From: Anita Gardner
Sent: 14 December 2018 14:17
To: Karen Parsons
Subject: FW: LU/260/18/HH 22 Roman Acre, Littlehampton
Attachments: 1179.02.d Proposed A1.pdf

From: Lauren Willard [REDACTED]
Sent: 13 December 2018 17:37
To: Anita Gardner
Subject: LU/260/18/HH 22 Roman Acre, Littlehampton

Drawing Number: 1179.02.c

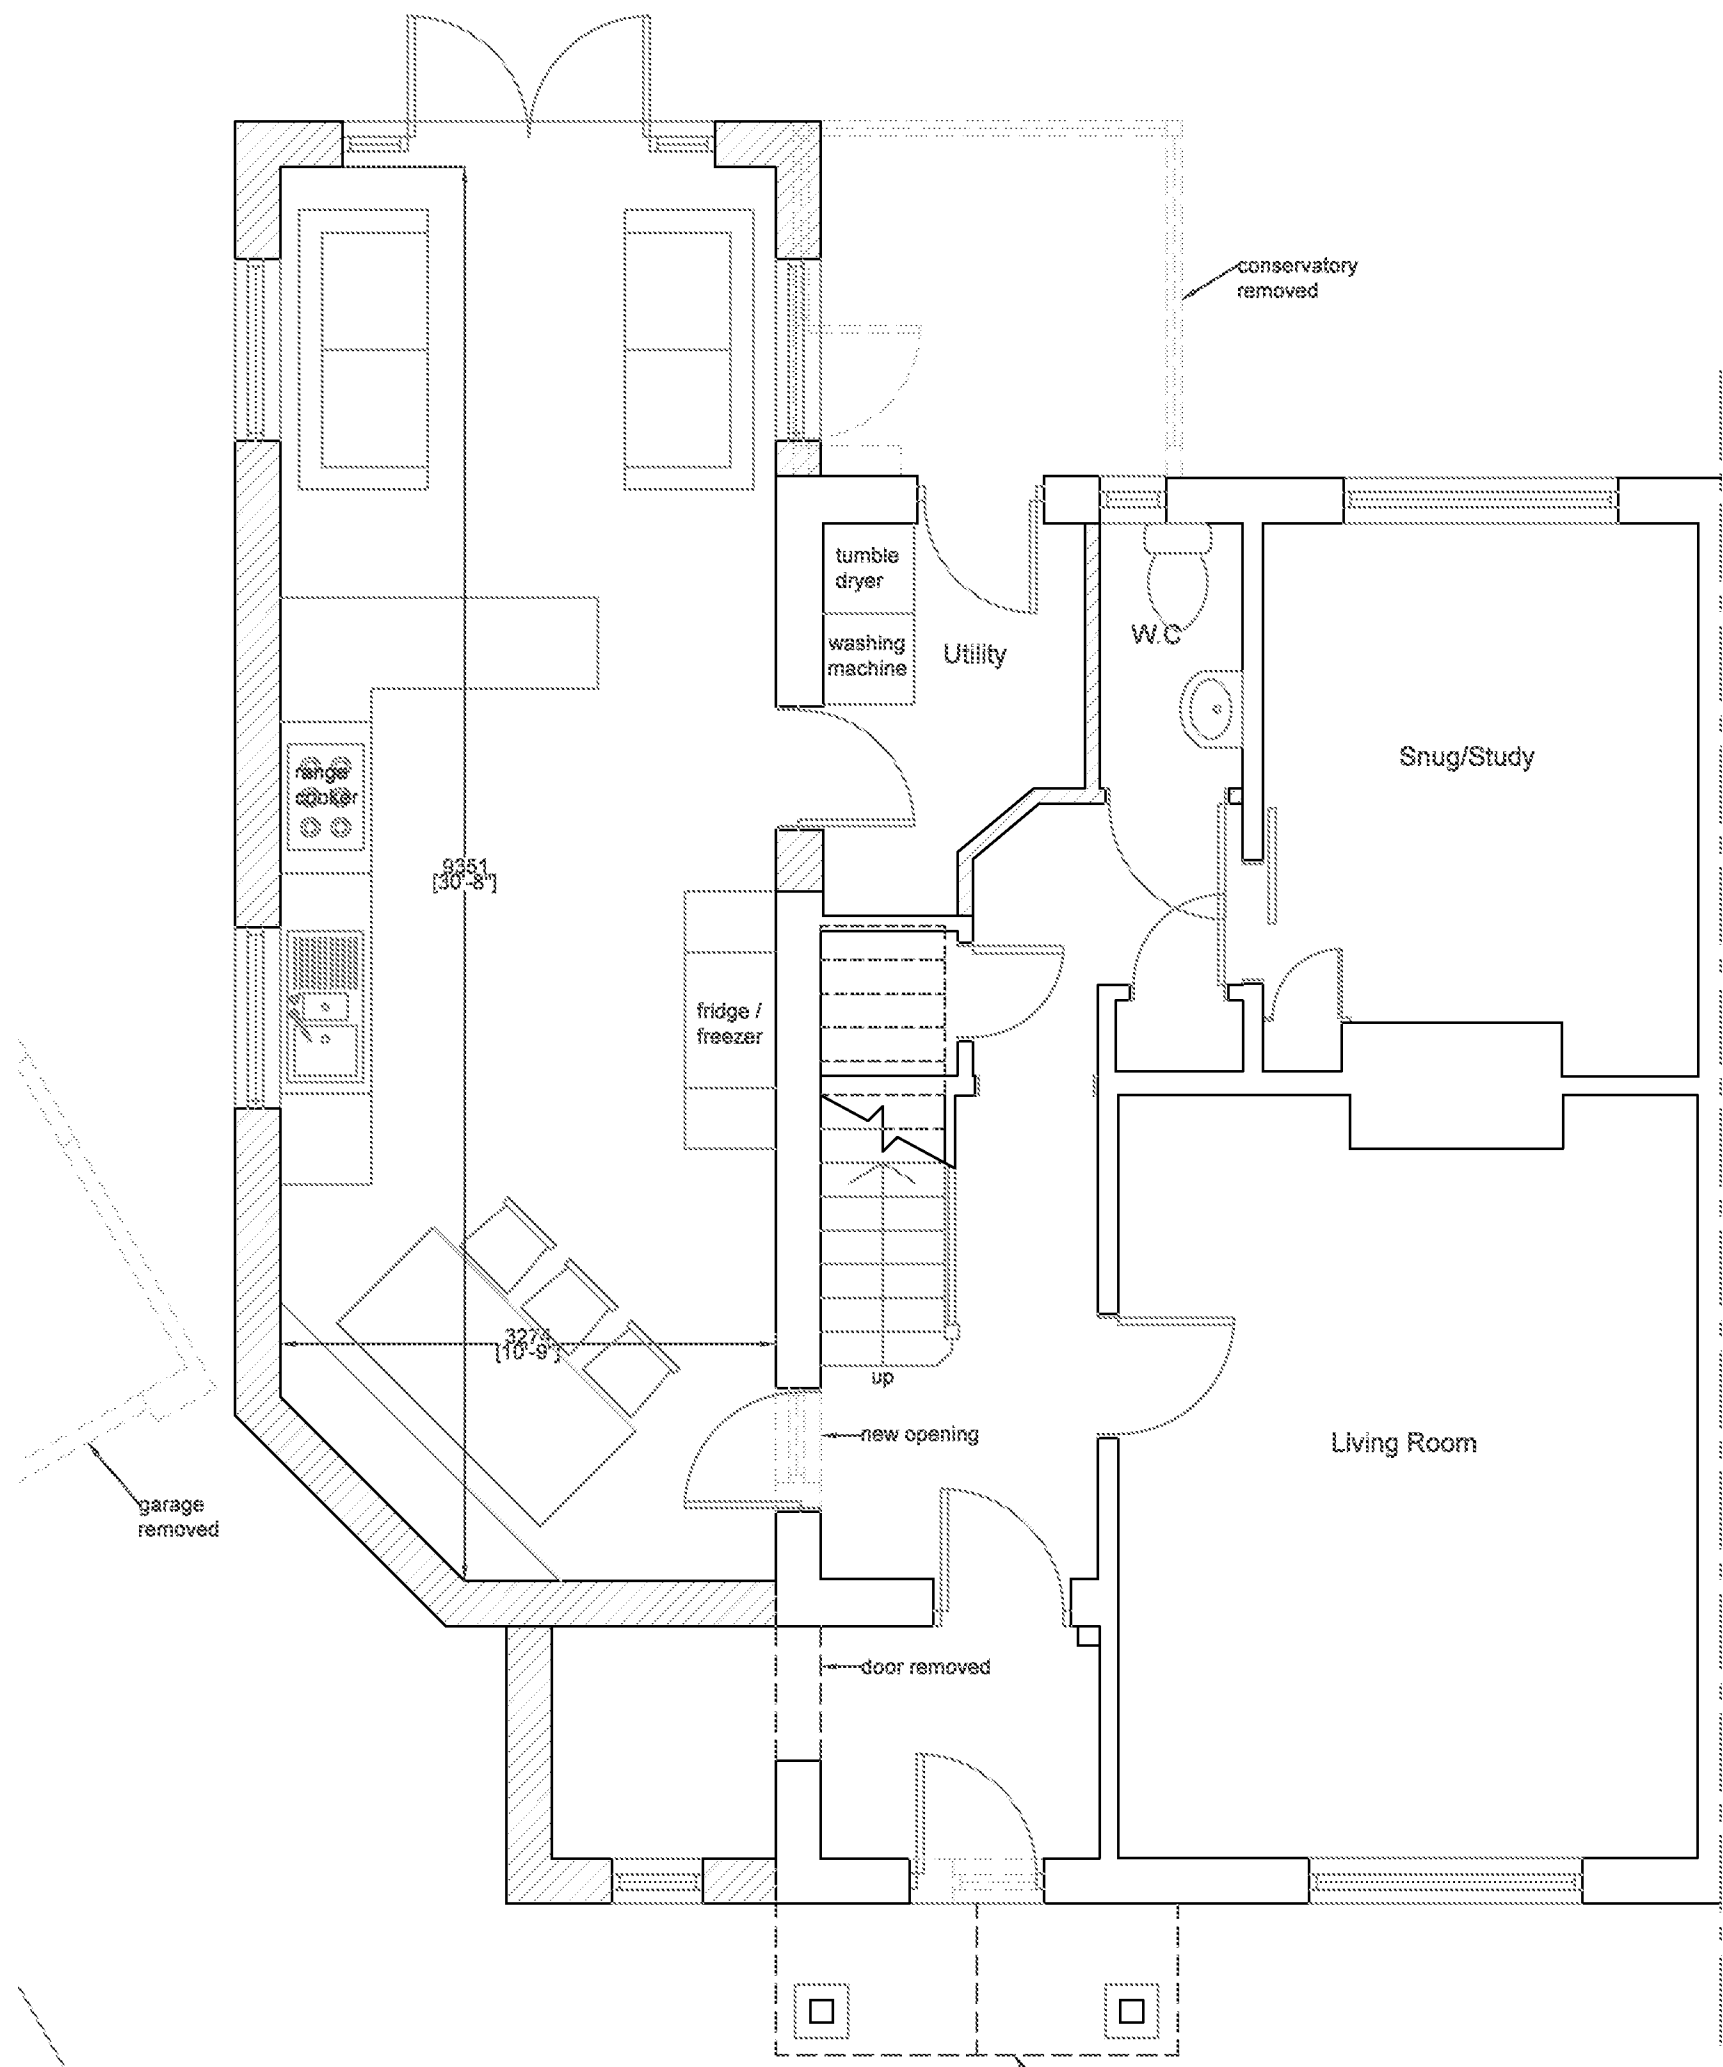
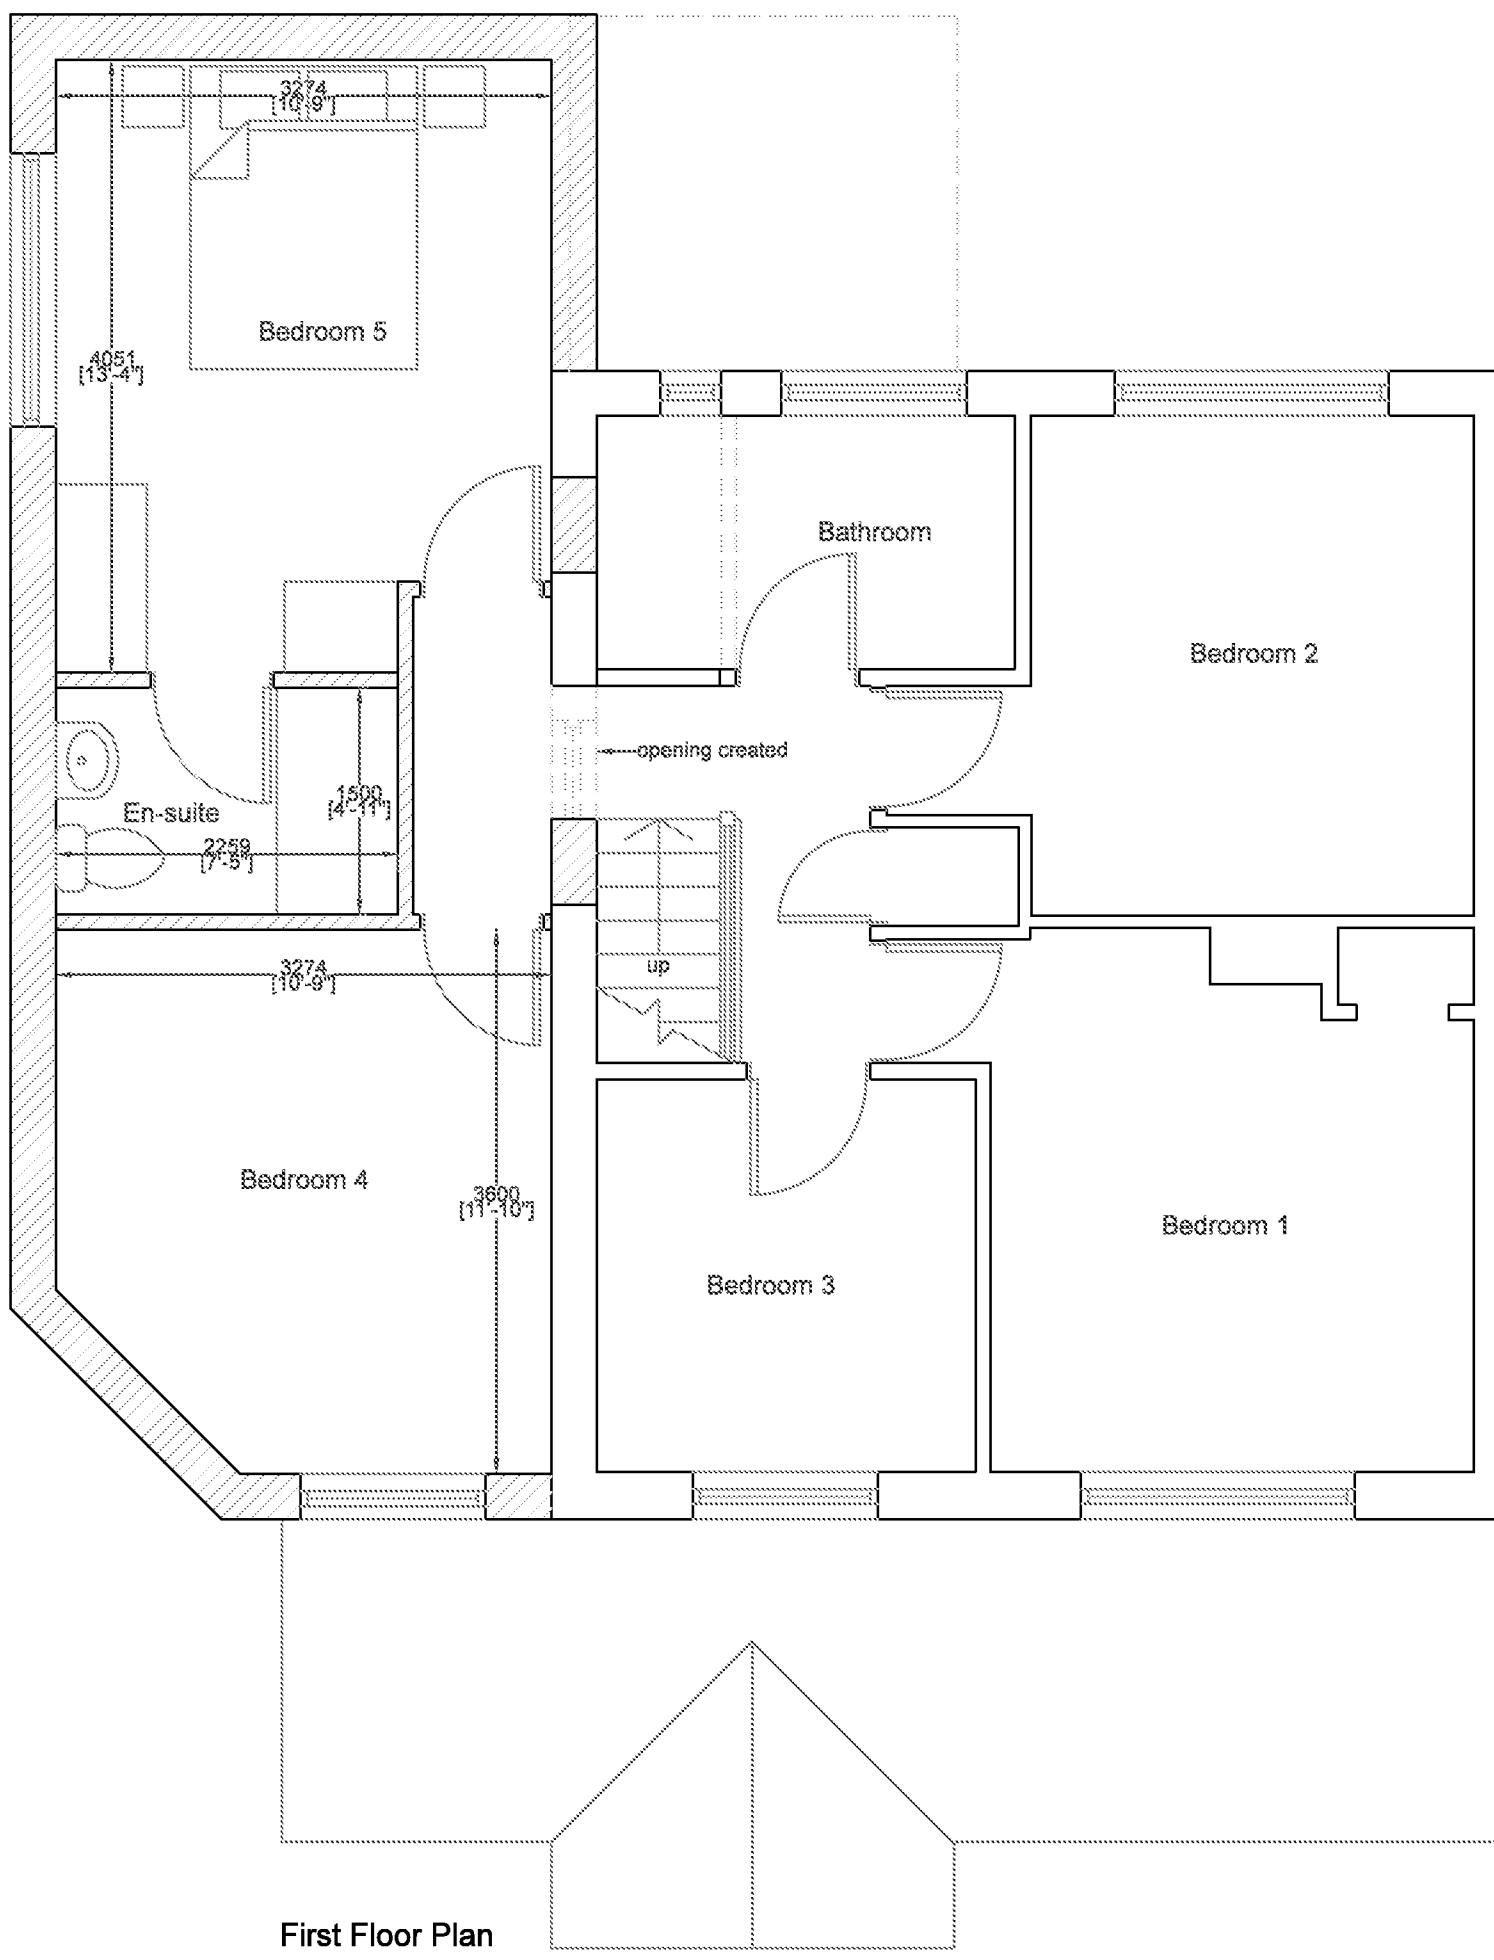
There is a change that the client would potentially like to move the side of the proposed extension out to the side of the property by an additional 300mm would it be possible to substitute a revised drawing for this? I will be able to get this to you tomorrow (Friday) if you would accept it.

Please find attached the amended drawing that we would like to substitute.

I can agree to accept revised plans showing this alteration as long as you agree to an EOT until the end of next week 21-12-2018 to allow for receipt and processing of plans.
